Gatwick Airport Northern Runway Project

Change Application Report

Application Document Ref: 9.2

Figure 58. North Terminal IDL Extension (South) Indicative Site Context Plan

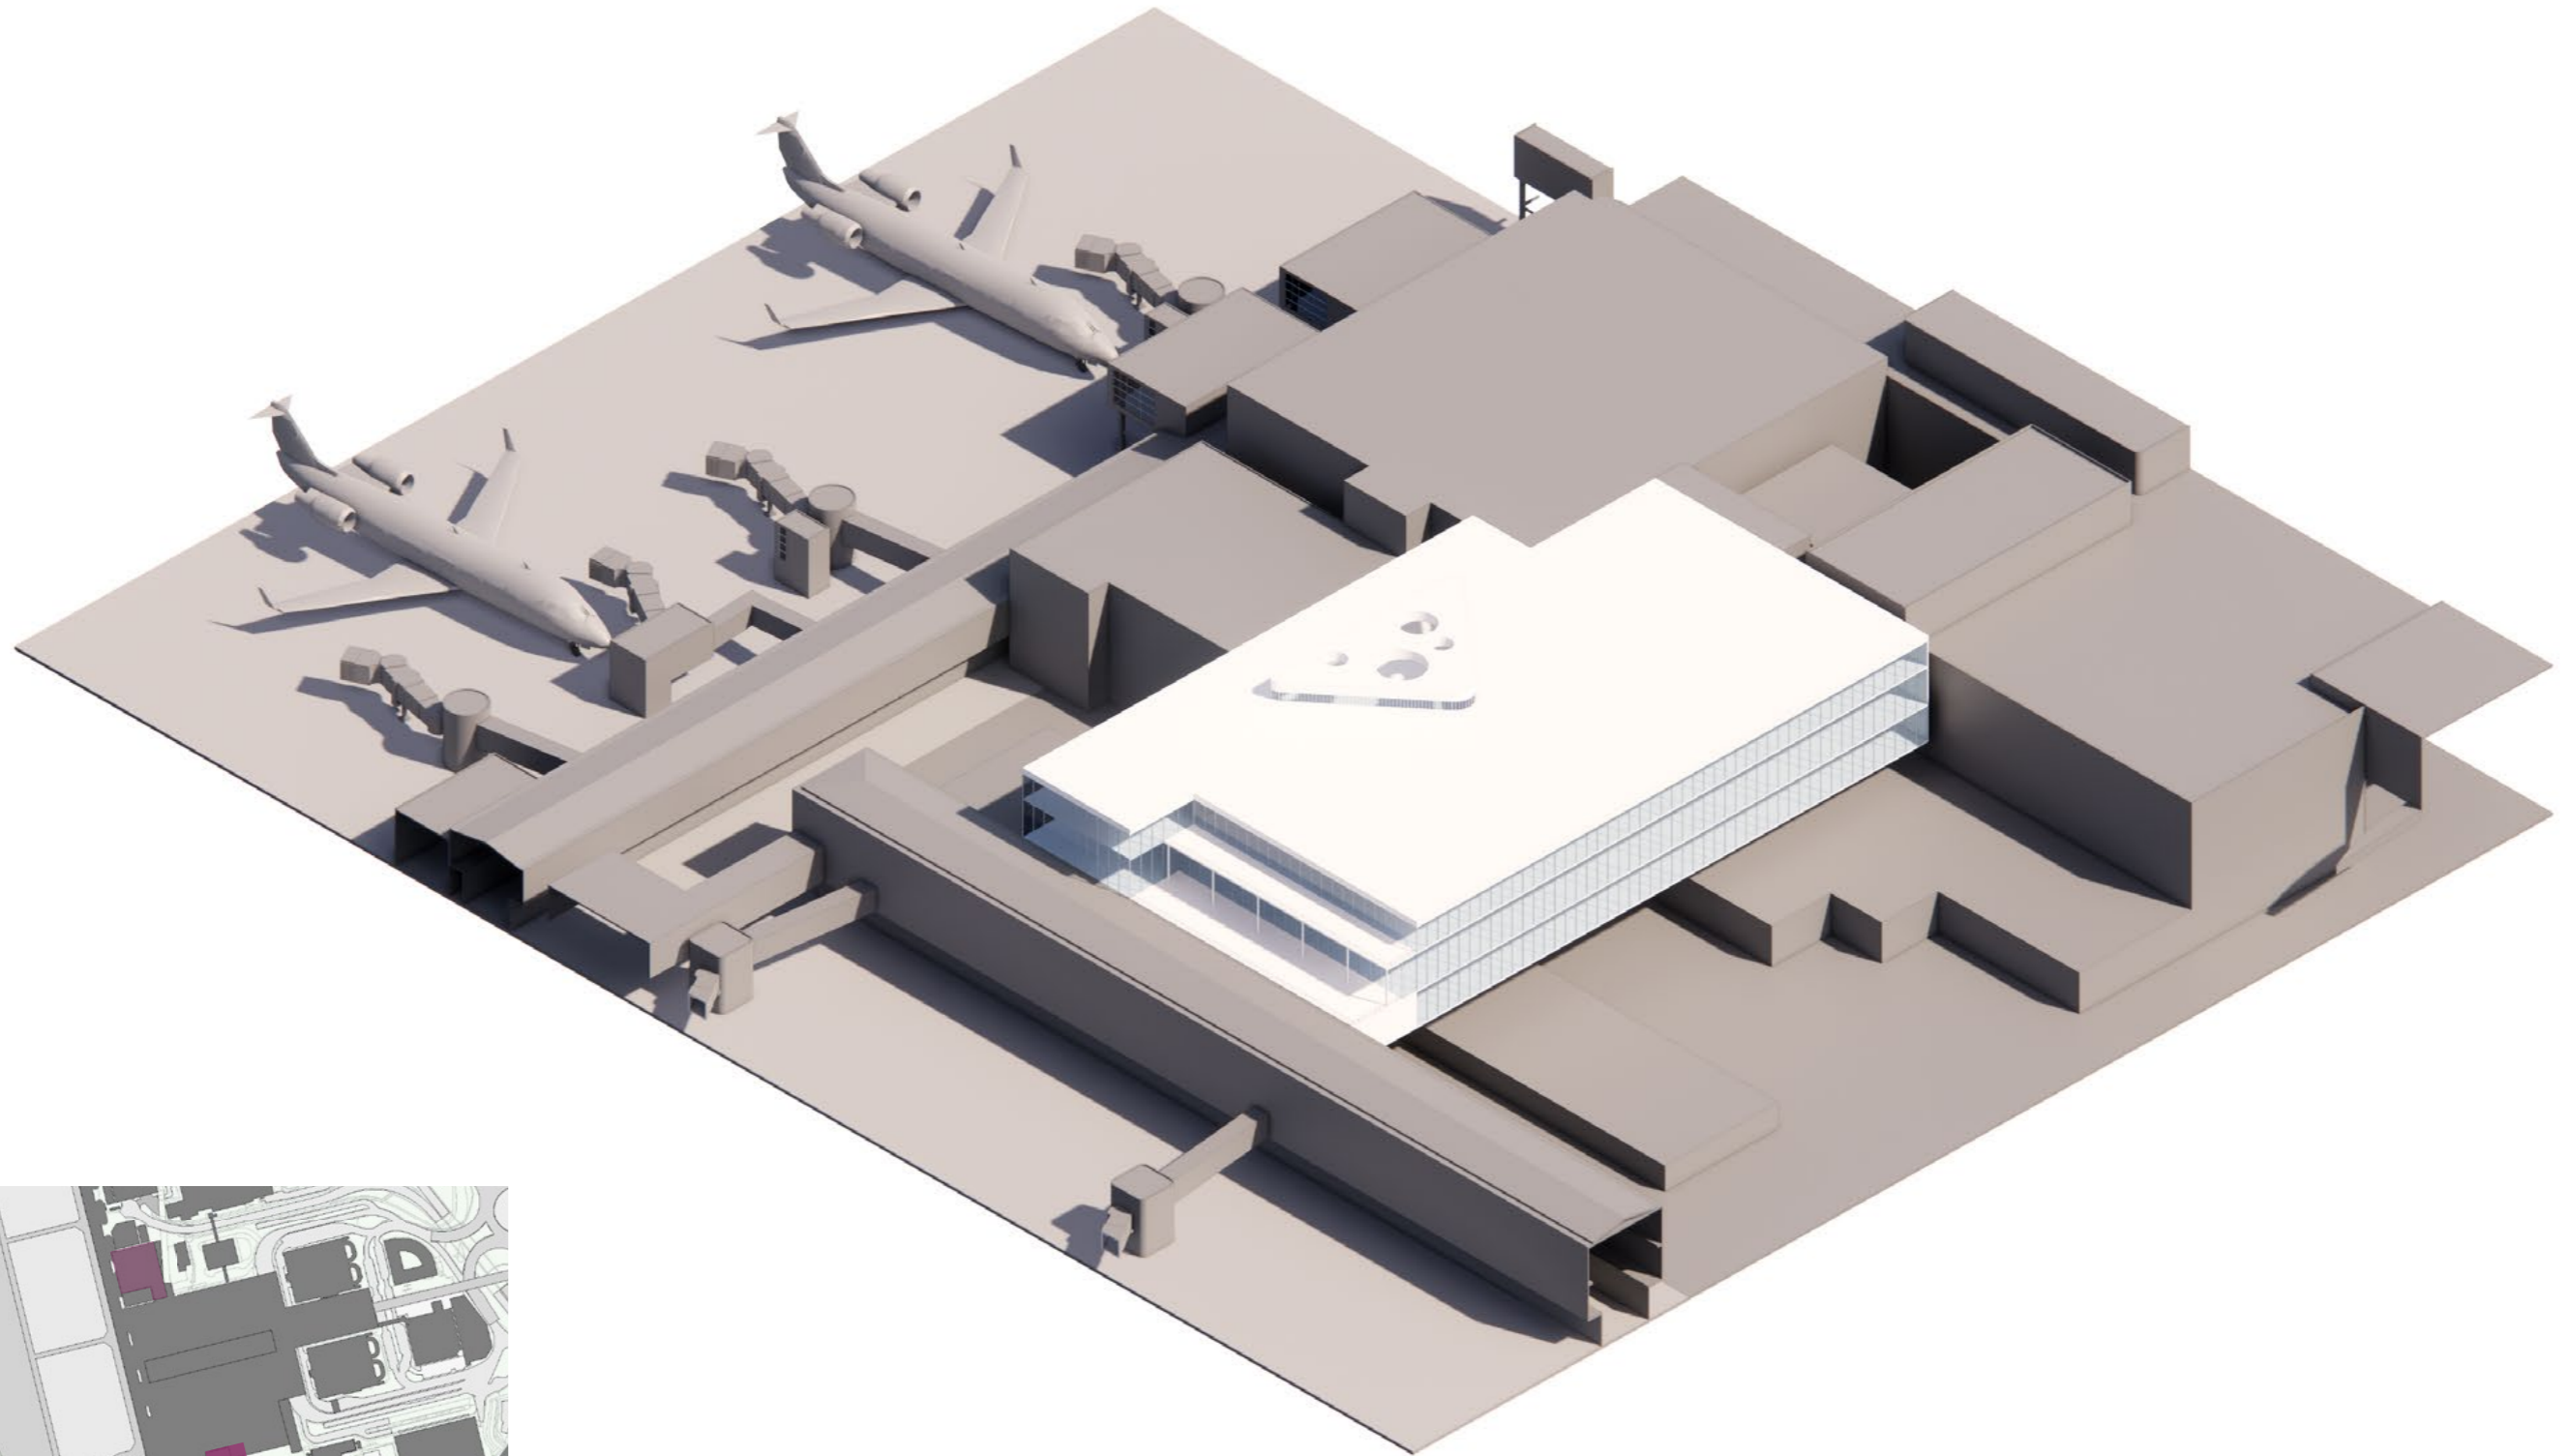
3.1.2 The first change ("Project Change 1") proposes amendments to the southern extension from that described within the Application, as set out below. Project Change 1 does not entail any changes to the northern extension of the IDL, which remains as set out in the Application.

- Increase in the maximum plan parameters from up to 119 x 105 metres (width x length) to up to 120 x 175 metres.
- Increase in the maximum height parameter (above ground level) from 27.5 metres to 30 metres.
- Demolition of the CIP lounge building and the circulation building.

3.1.4 The changes to the maximum parameters are shown in **Figures 2 and 3** below, along with labels identifying the location of the CIP lounge building and circulation building to be demolished.
